CITY OF PORTLAND, MAINE
 DEVELOPMENT REVIEW APPLICATION
 PLANNING DEPARTMENT PROCESSING FORM

2005-0235

Ruby Land #13

FIGURE
1300

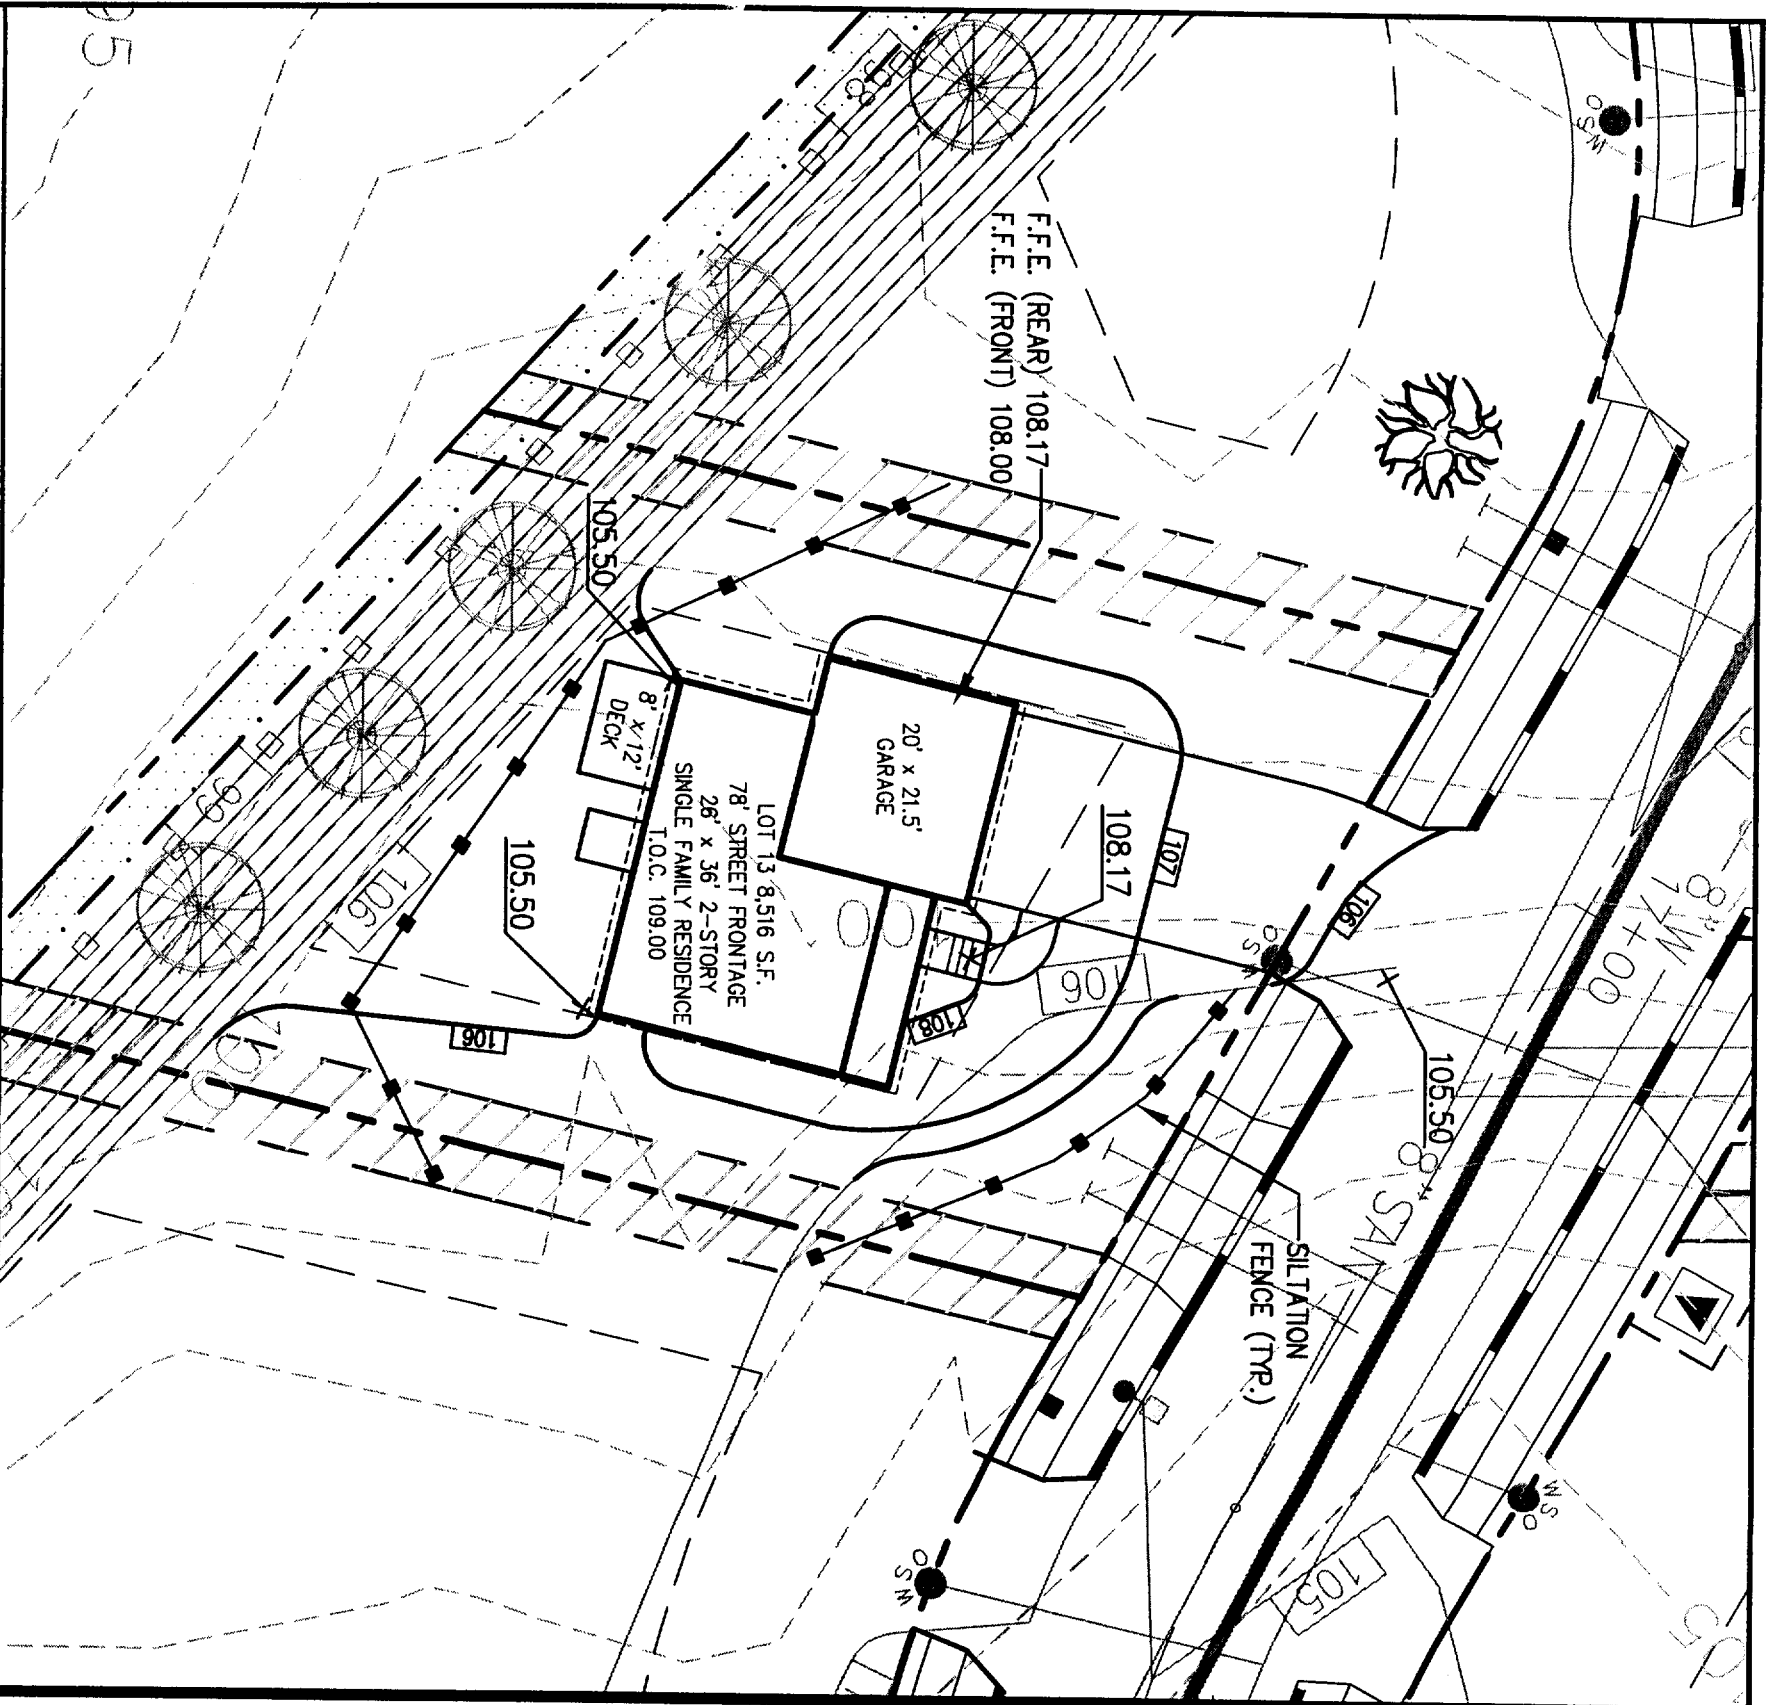
How of Tree off lot 1's - New Elevations
 Reverse Pitch in Rear
 Adjust FFE Accordingly
 Cons Got location based on match 58.
